Comments to planning application 2023/60/93342/W

“Demolition of Existing Dwelling and Garage. Erection of Two Detached Dwellings with Attached Garages.”

At: Moss View, Burnlee Road, Holmfirth, HD9 2LE

Comments From: The Dell, Burnlee Road, Holmfirth HD9 2LF
I live next door to the proposed development.

PROPOSED SIMPLIFIED STREET ELEVATION
 (NOT ALLOWING FOR DWELLING ANGLES - FOR GENERAL HEIGHT PURPOSES ONLY)

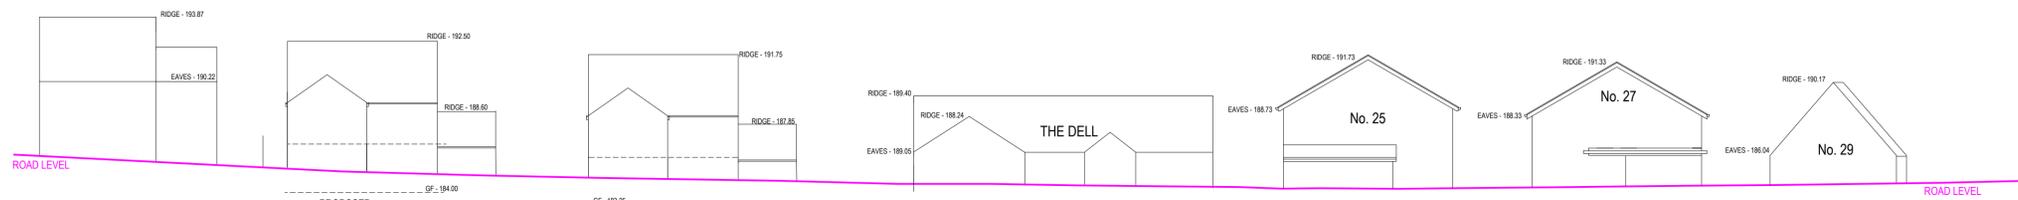
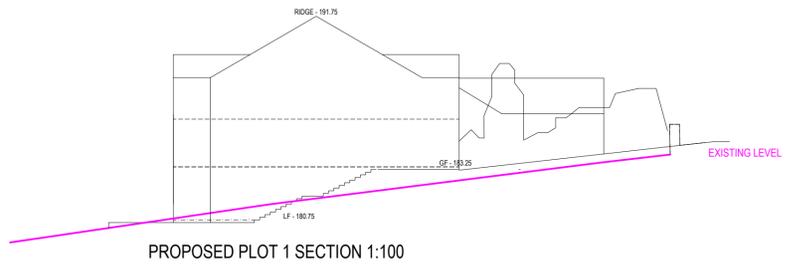
The proposed roof heights will obscure the sky from the bedroom windows.

SITE PLAN (1:200)

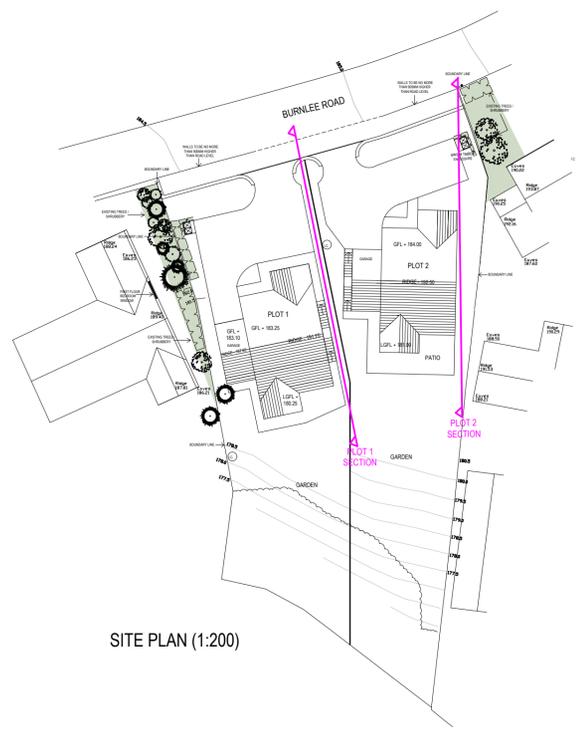
Water on Burnlee road can currently go through the existing dry stone wall at Moss View and soak away into the field (the lawn). If the drystone wall was replaced with curbstones or something more watertight, significant extra surface water would flow along Burnlee road and enter into my driveway at The Dell.

The proposed patios will overlook my bedroom window and garden. Suggest they are lower down, screened, or not built.

Actually, Moss View represents the biggest gap in the footway on the south side of Burnlee Road.

If the developer were to move the drystone wall back and make a footway, and add drainage gulleys, then I (The Dell) would be minded to do the same to match.
